**Our ref:** 26\_34296\_P

**Your ref:** H16-1191-25

**Site Location:** 39-41 Albert Street Spalding PE11 2LD

**Summary of Proposal:** Demolition of redundant commercial buildings and the erection of 5 dwellings

PROPOSED BLOCK PLAN

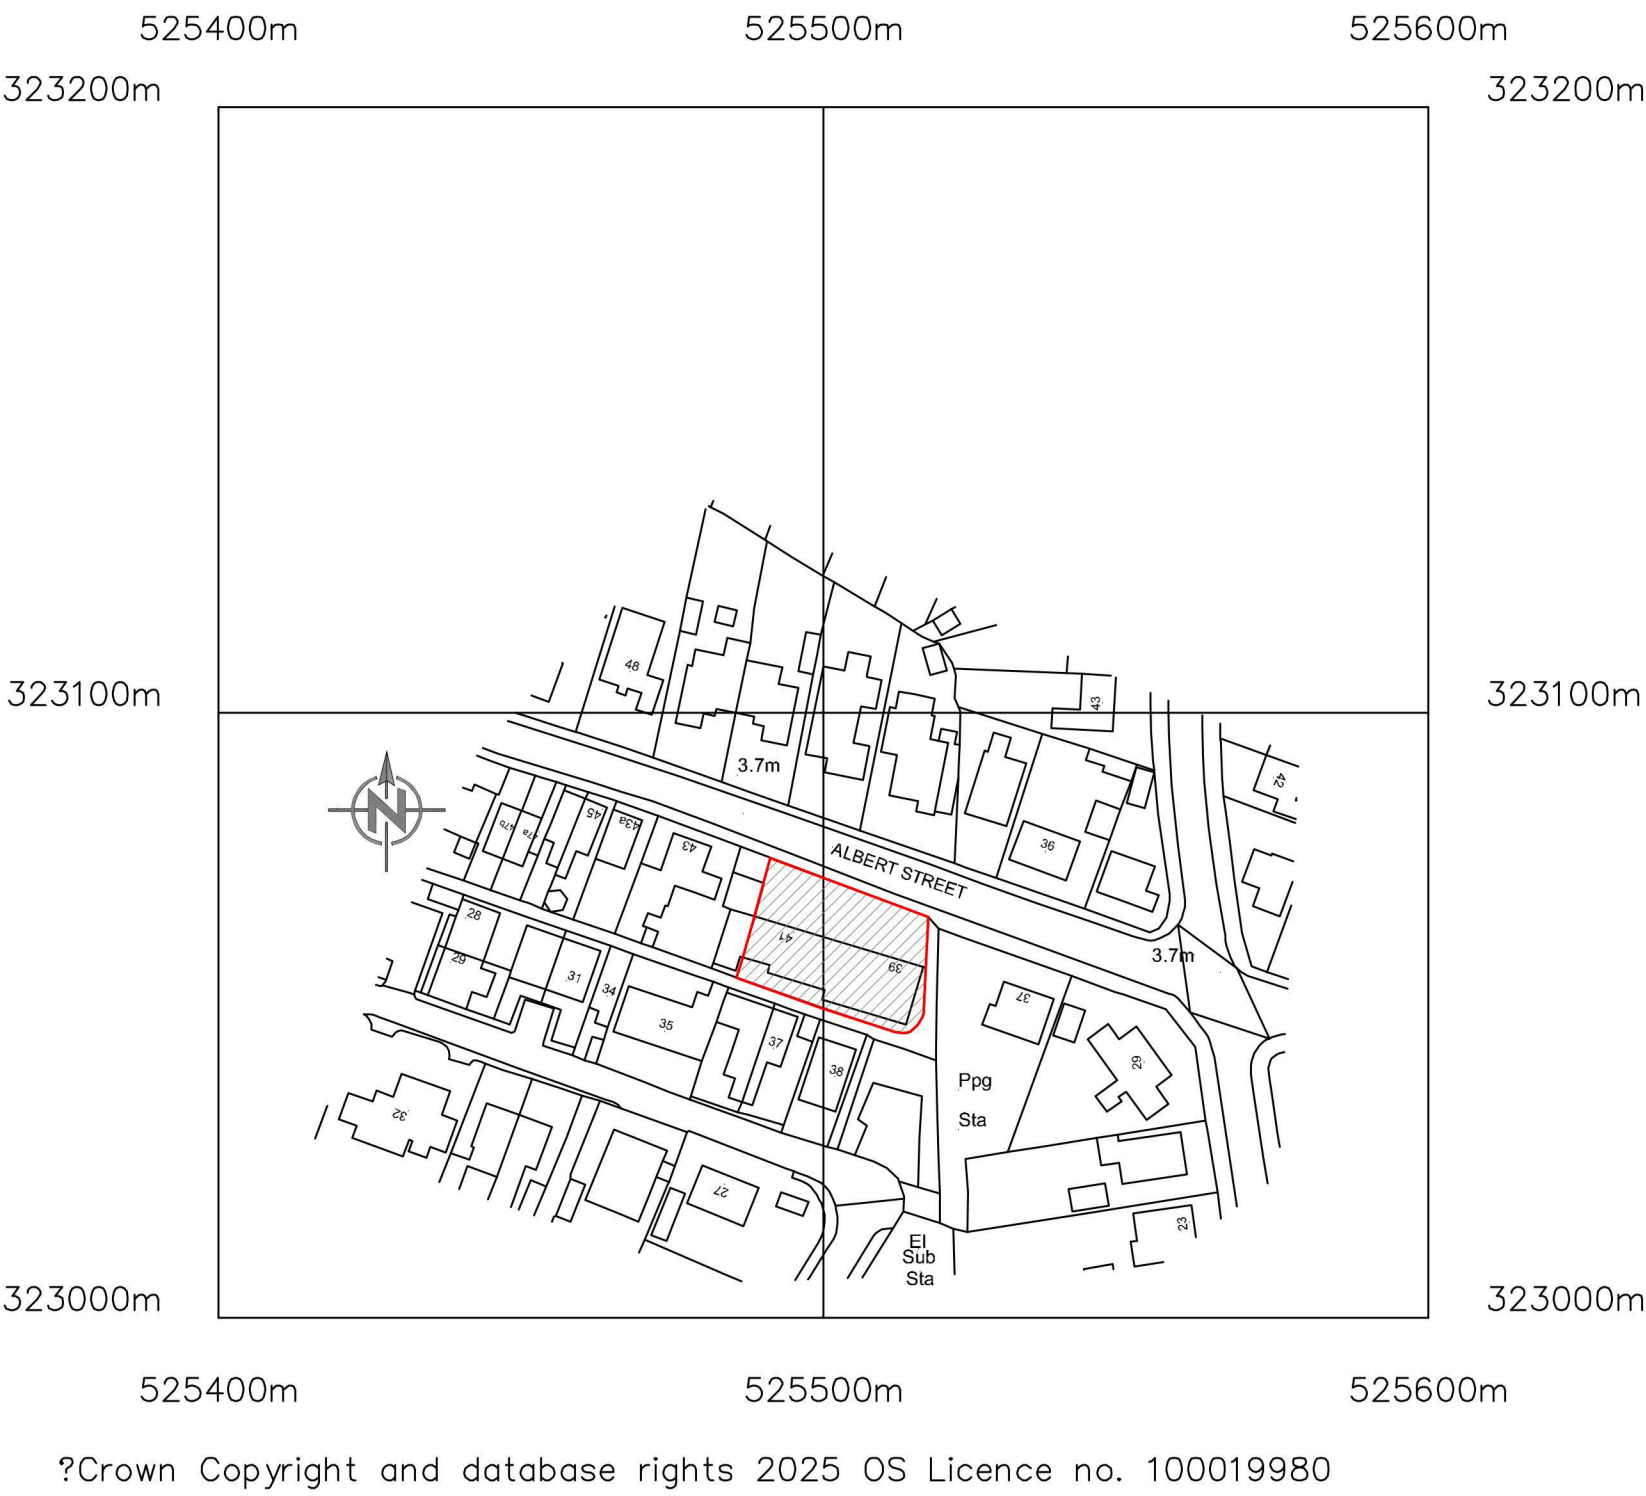
I note that the applicant intends to construct the easternmost dwelling approximately 4.5 metres from the aforementioned Board arterial watercourse. This is within the 9 metre Byelaw Zone, and the proposed works are not considered acceptable under the Board's [policies](#) due to the permanent nature of the development. Therefore the Board **objects** to this proposal.
